WEST SUSSEX COUNTY COUNCIL CONSULTATION

TO:	Arun District Council FAO: Simon Davis
FROM:	WSCC – Highways Authority
DATE:	16 th April 2026
LOCATION:	Land North of Summer Lane Pagham
SUBJECT:	P/30/26/OUT Outline application with some matters reserved, except access, for up to 120 No residential dwellings including means of access into the site (not internal roads). This application is a Departure from the Development and affects a Public Right of Way.
DATE OF SITE VISIT:	10 th April 2026
RECOMMENDATION:	No Objection

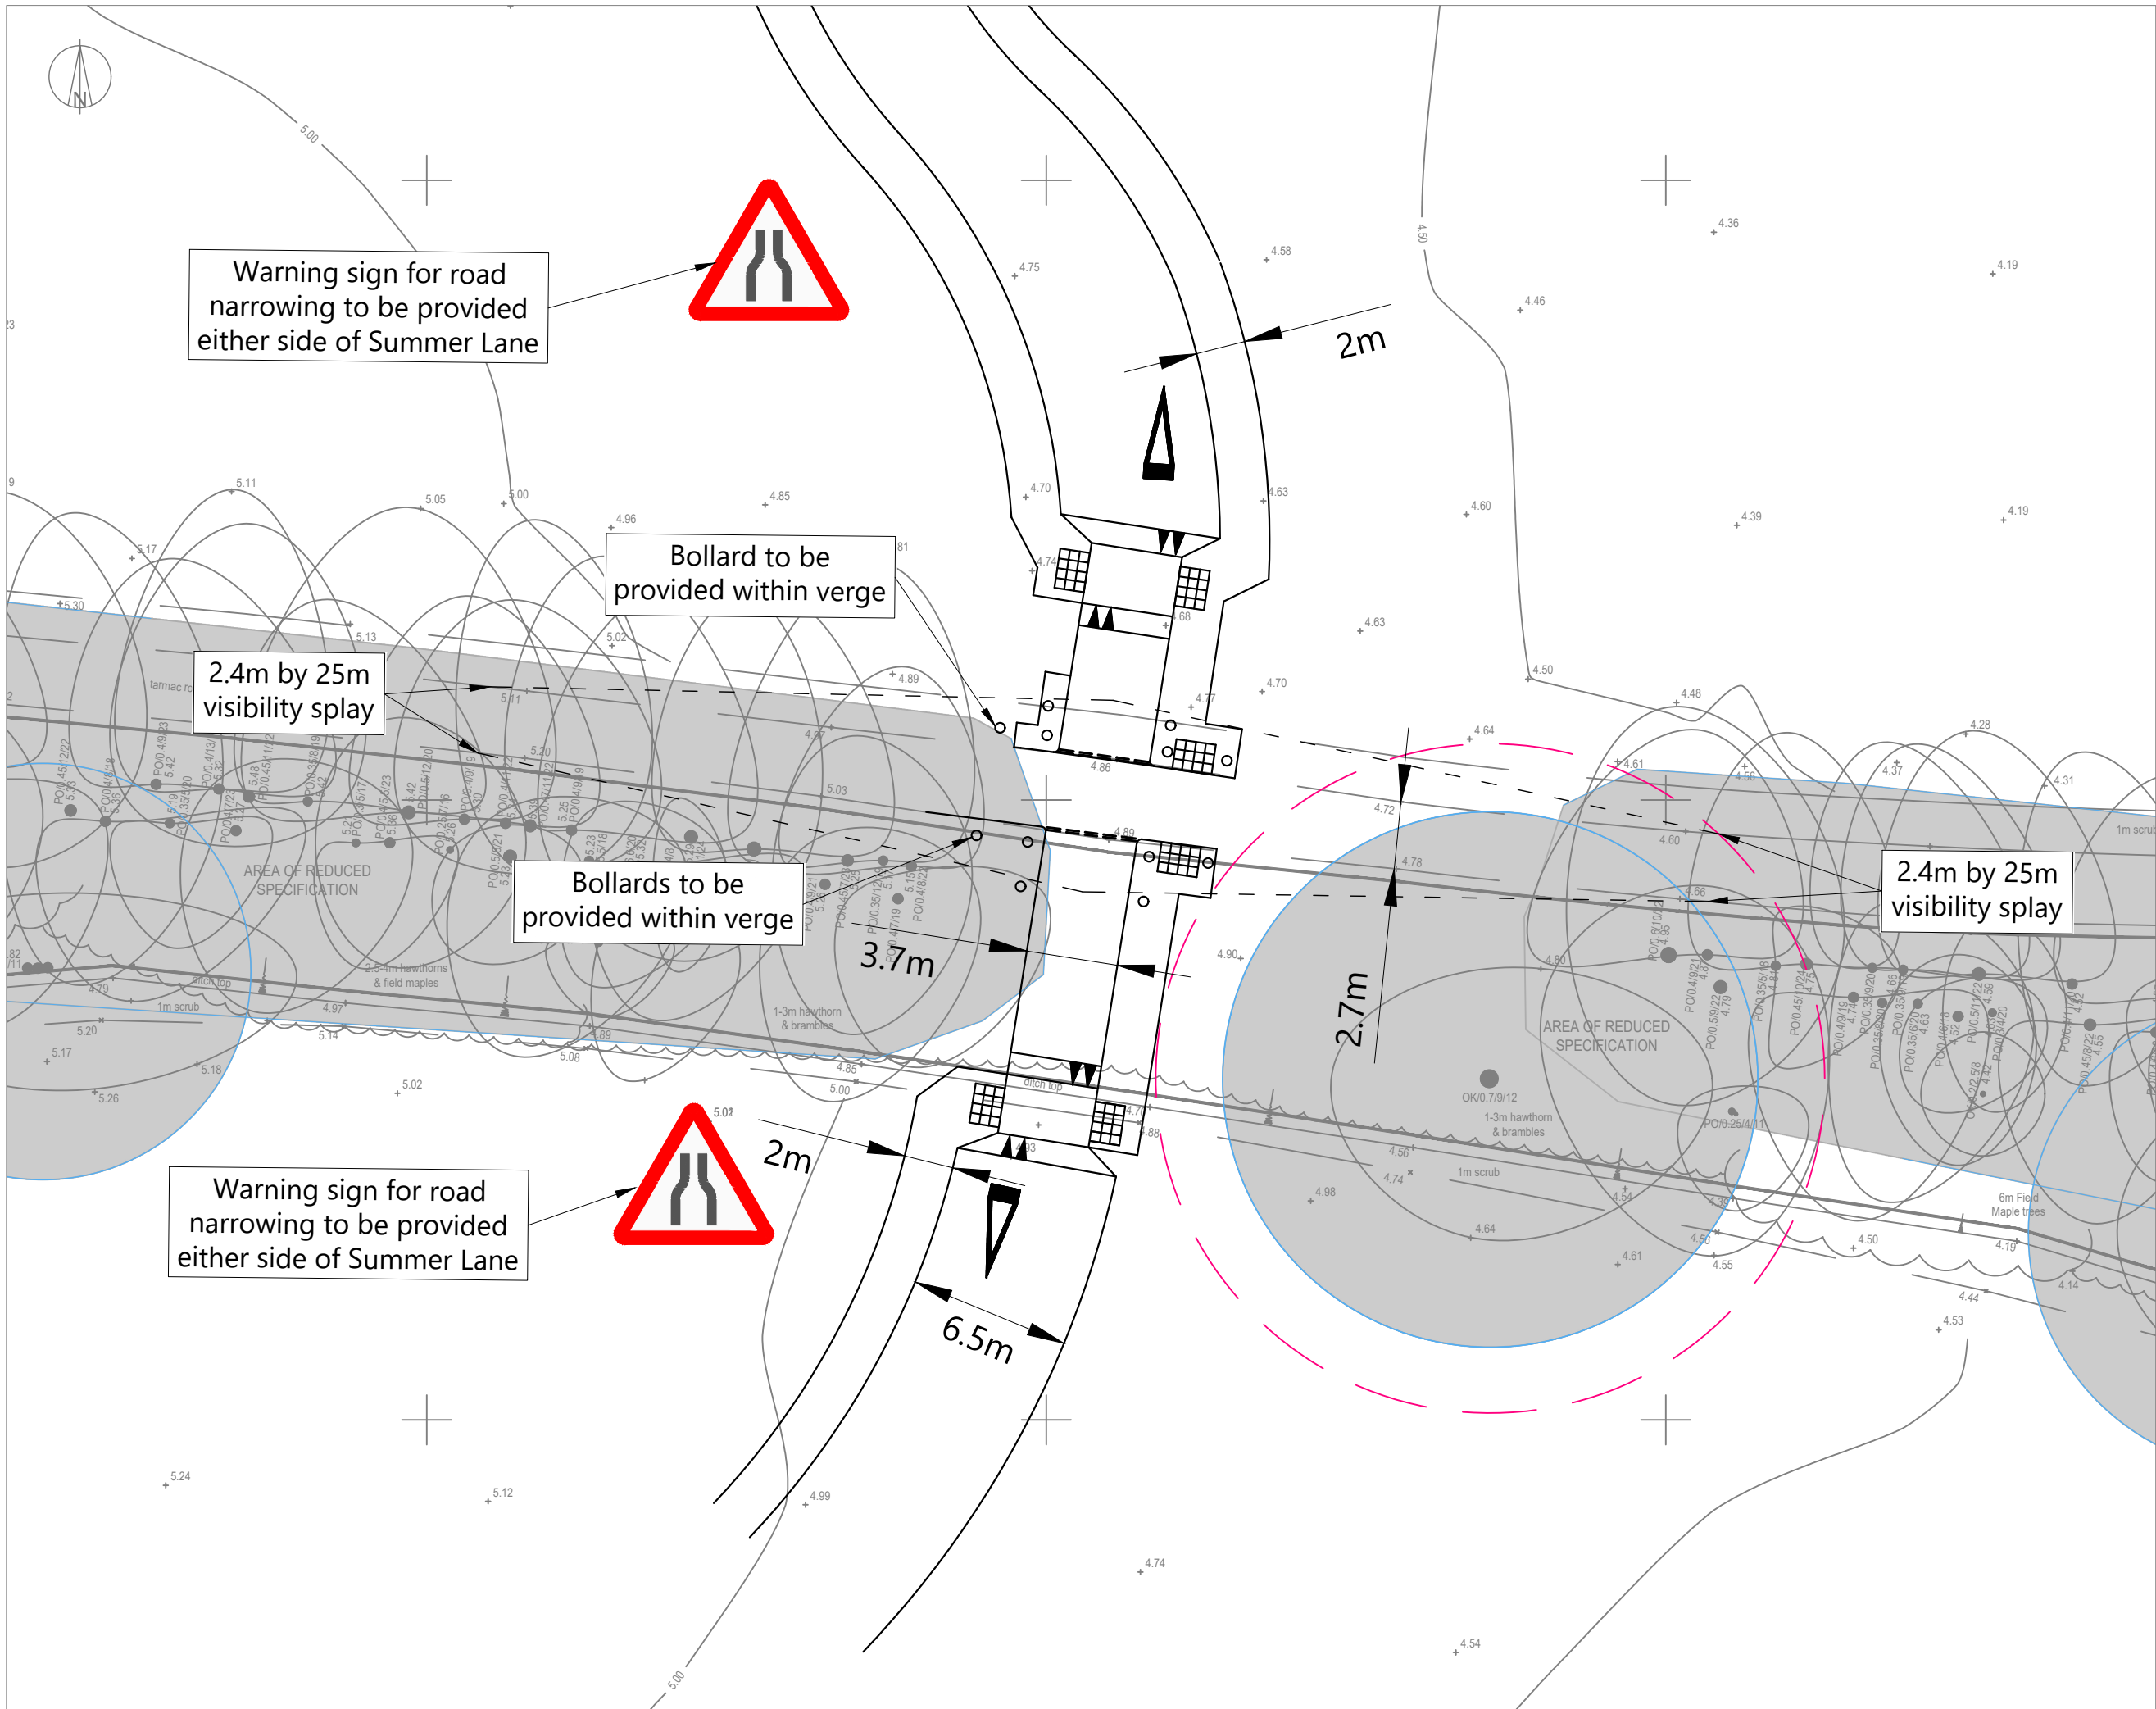
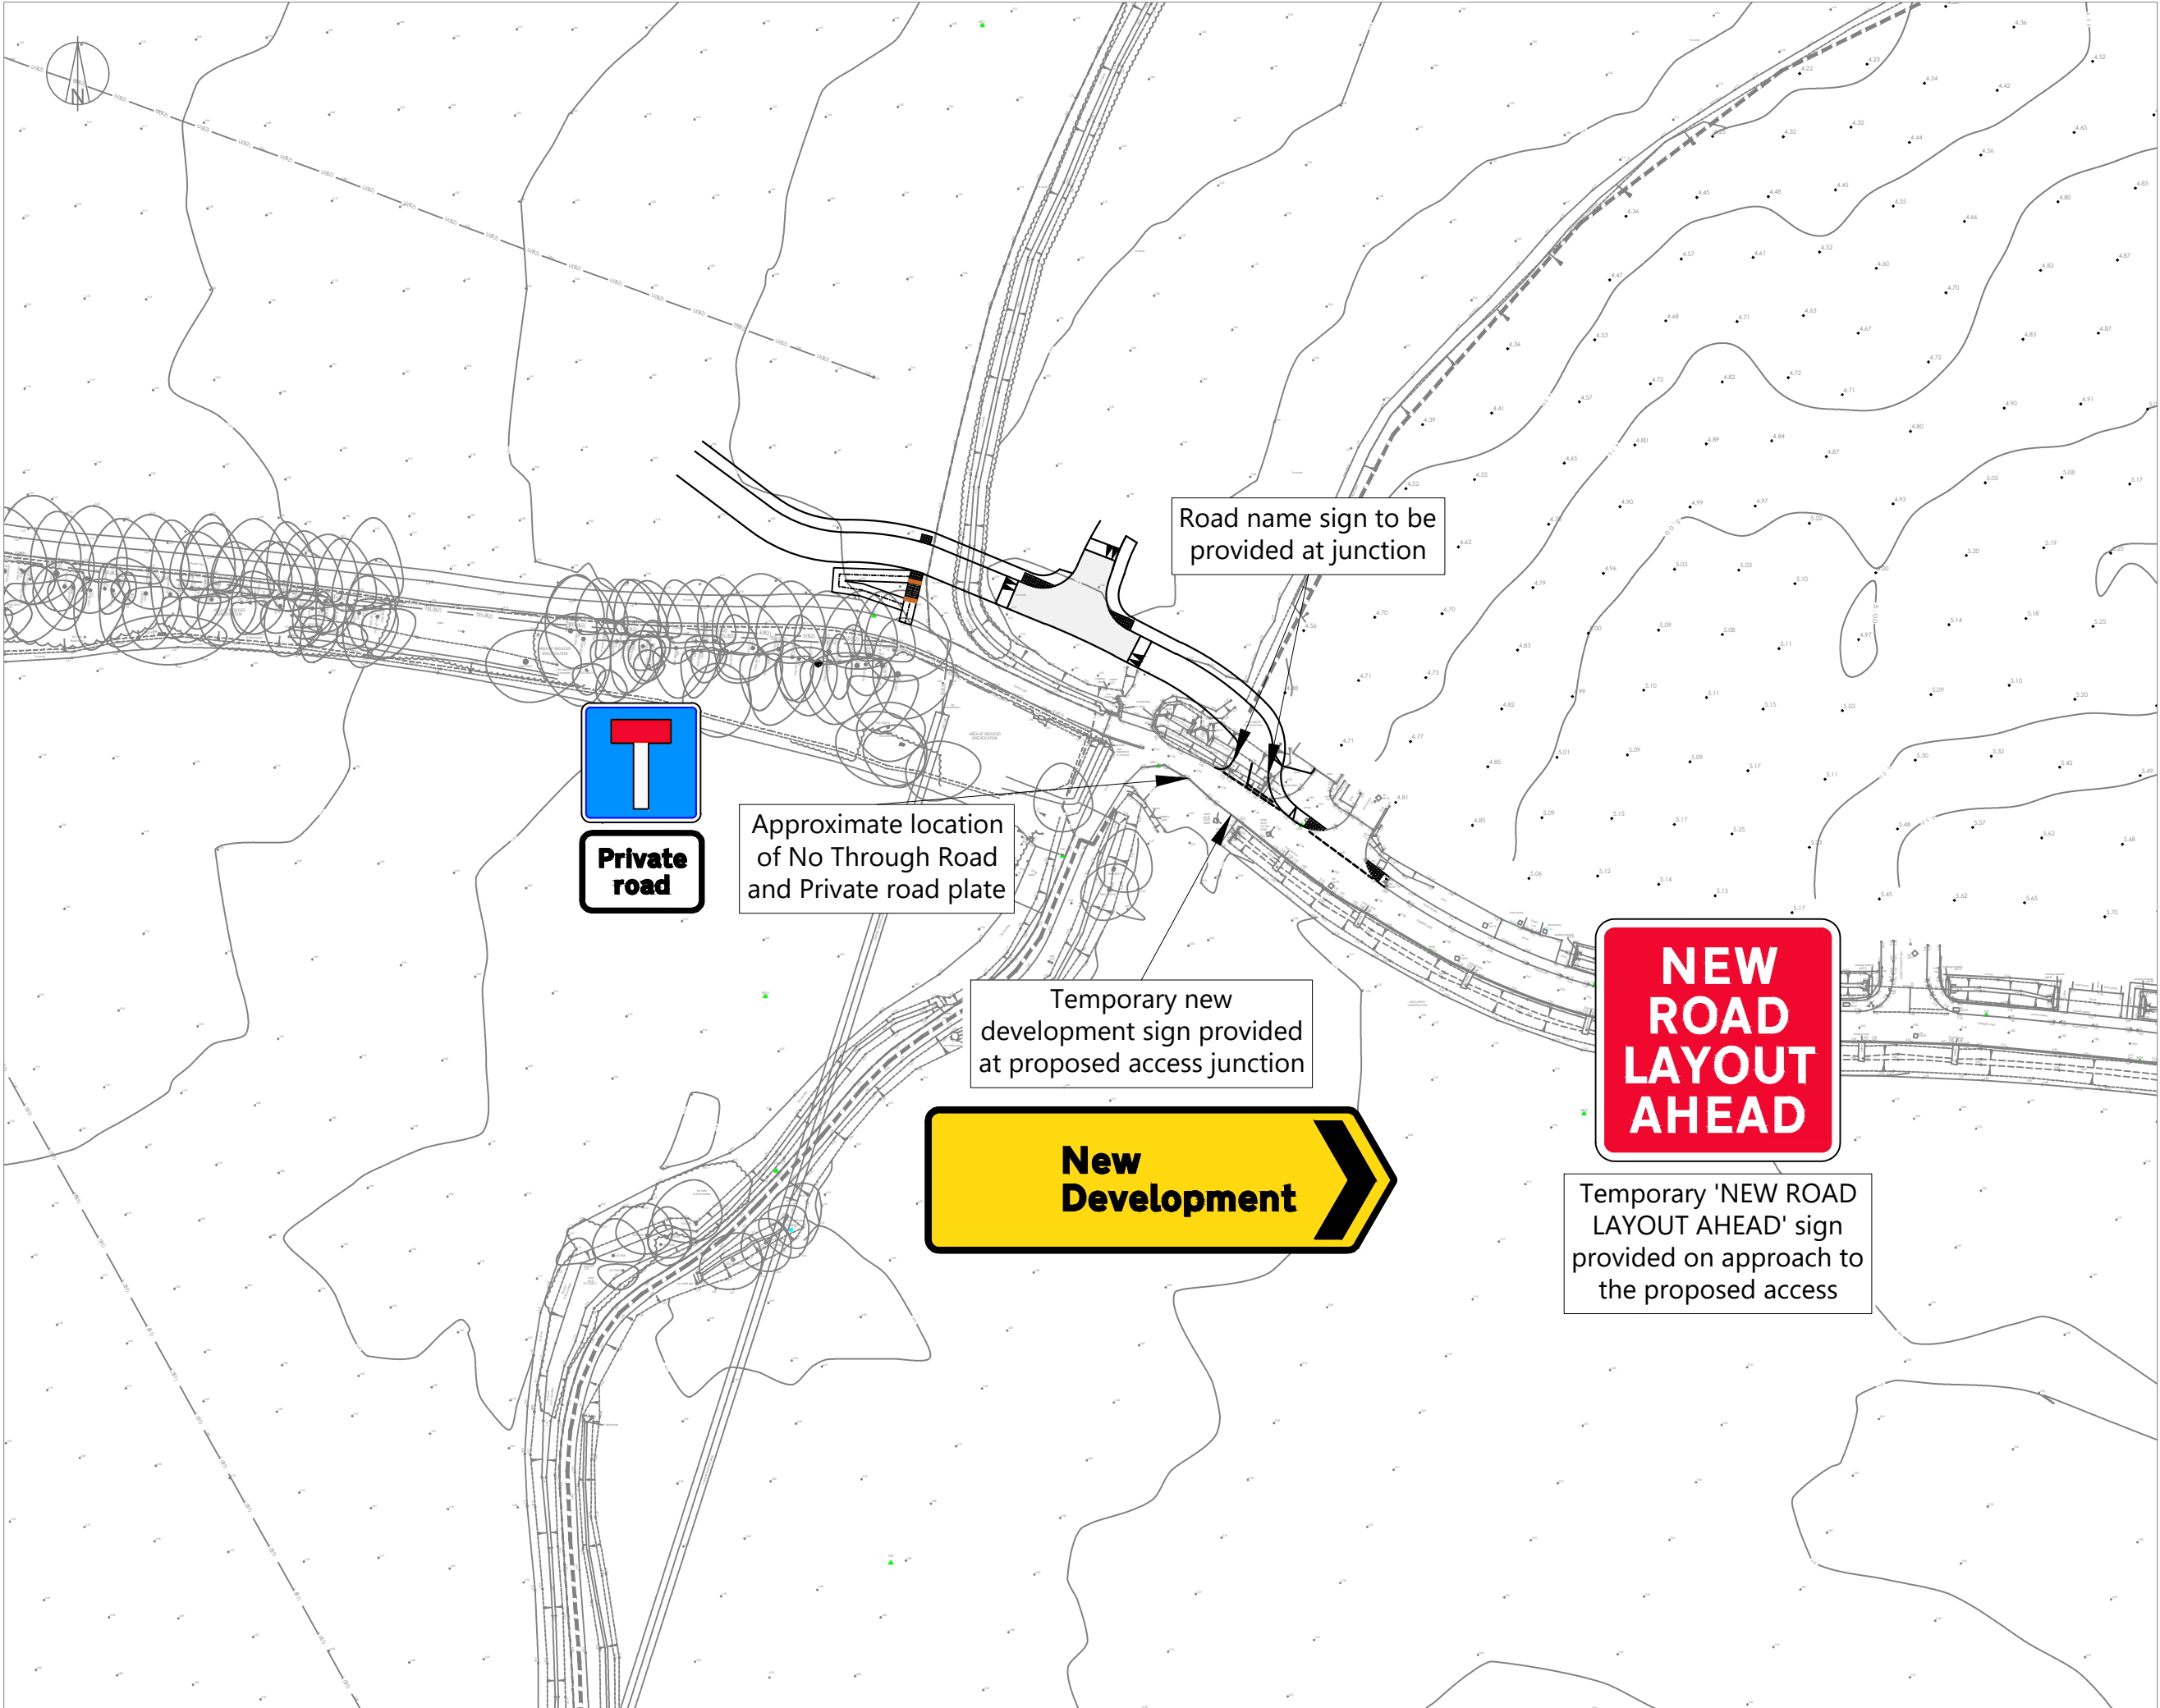
The part of the application proposes a new 5.5m wide access provided directly onto Summer Lane as shown on Drawing 01 within the TA. The access will have 6m radii allowing large vehicles to be able to manoeuvre in and out of the access easily. A separate 2m wide footway will be provided into the site providing safe access for pedestrians. Tactile paving will be provided to allow crossing to the footways on the southern side of Summer Lane. The works for the access would be subject to a Section 278 Agreement with the LHA's Highway Agreements Team.

Drawing 01 shows the site access details, this will include a carriageway of 6.5 metres narrowing to 3.7m, to reduce vehicular speeds and reduce crossing distance, with a raised table and tactile paving to promote safe use of the crossing. Drawing 01 shows visibility splays of 2.4 by 25 metres at the point of access, working on a 20-mph limit. The splays as shown are considered sufficient for the likely vehicles speeds. No forward visibility splays have been provided; however, the layout is considered acceptable to promote sufficient forward visibility for drivers, cyclists and pedestrians.

Drawing 01 shows to the south of Summer Lane, a 2.0-metre-wide footway is shown on the western side of the carriageway, crossing to the eastern side and continuing across Summer Lane to the northern side of the access road. In principle, the LHA would be satisfied with the arrangements as demonstrated.

No part of the development shall be first occupied until such time as the vehicular access serving the development has been constructed in accordance with the details shown on drawings 01 Sheet 1 of 2 and 01 Sheet 2 of 2.
